**7080 Shoup Road, AL-19-004**

**Please accept the following comments from El Paso County Public Health regarding the proposed rural home occupation and equipment storage yard:**

FILE # AL194

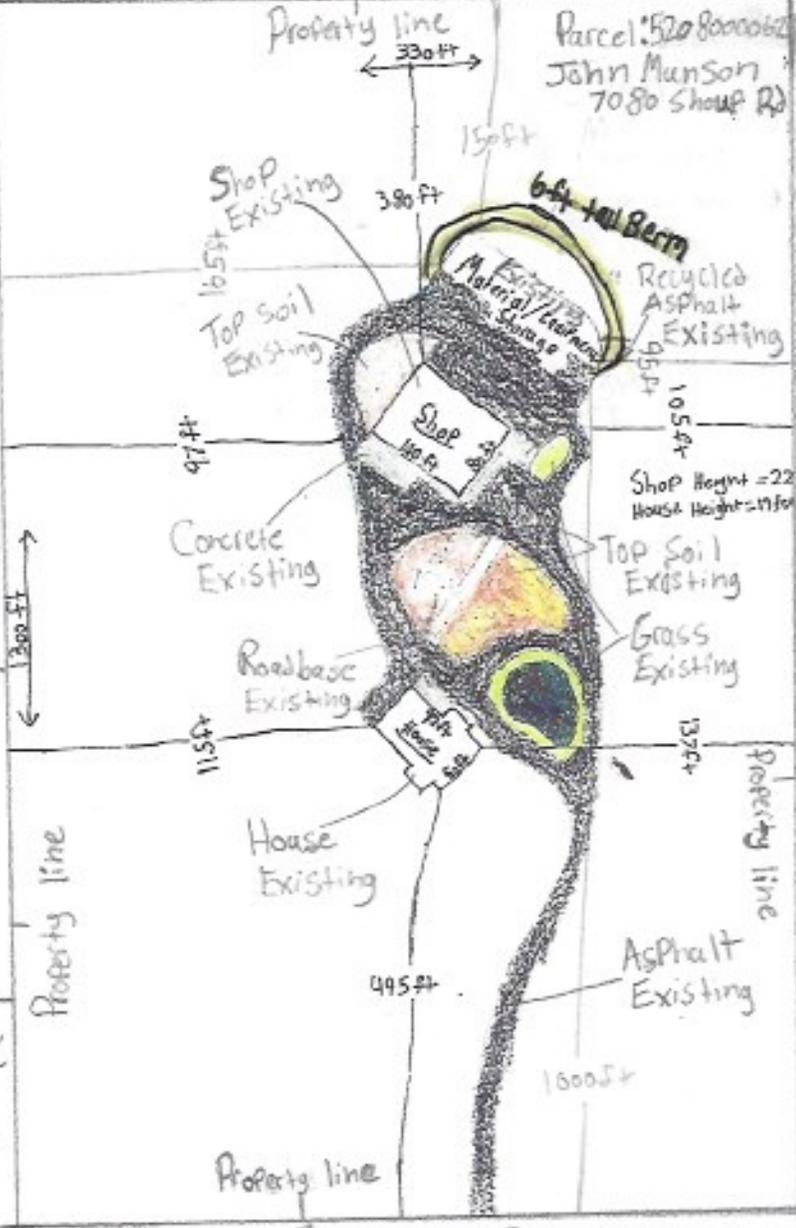
- **A record of an approved, permitted on-site wastewater treatment system (OWTS) for this property indicates the OWTS components are located on the south side of the house. Please make sure that the existing soil treatment area (STA) and a nearby equally sized STA replacement area remain protected from vehicular traffic and other means of damage by compaction.**
- **All maintenance waste, if any, or other waste generated from equipment maintenance such as fluids, batteries, oil or other such waste products must be stored, disposed, and/or recycled per existing local, state or federal regulations.**
